13 May 2022

Catriona Shirley
Senior Environmental Assessment Officer
Department of Planning and Environment
Locked Bag 5022
PARRAMATTA NSW 2124

RE: Exhibition of Environmental Impact Statement, Ascent Logistics Centre, 520 Gardeners Road, Alexandria [SSD-32489140]

Figure 6 Proposed Height Variations

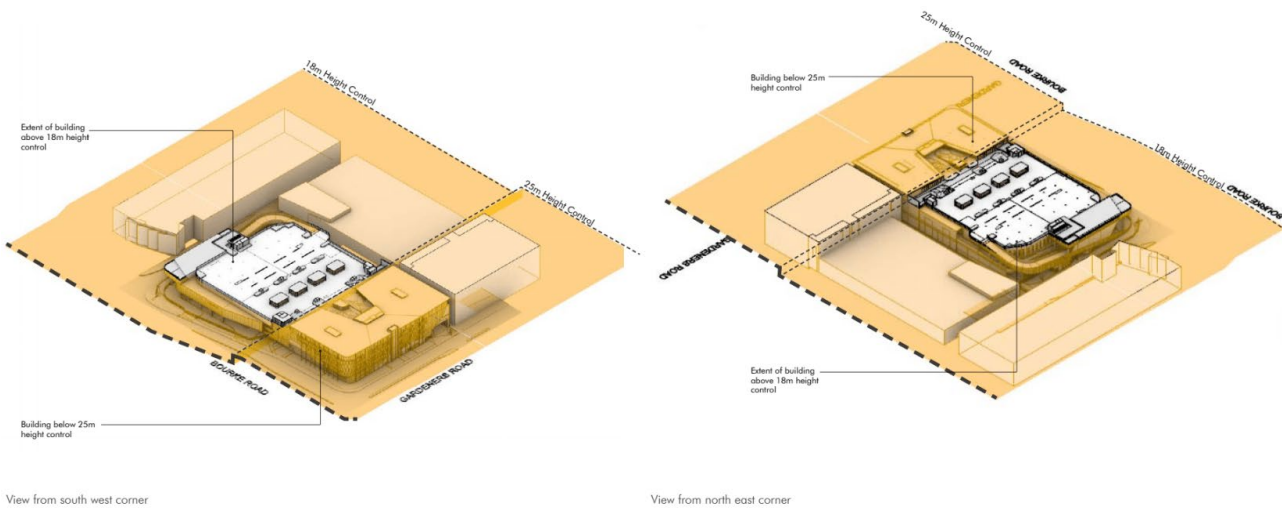
It is not clear if the Visual Impact Assessment has adequately taken into account potential impacts of the proposed development on the approved future residential development at 653 Gardeners Road. This includes potential impacts on solar access as a result of the proposed maximum building height of 22.59m on the northern part of the site, which exceeds the Height of Building control of 18m for this part of the site (and is the subject of a Clause 4.6 variation request).
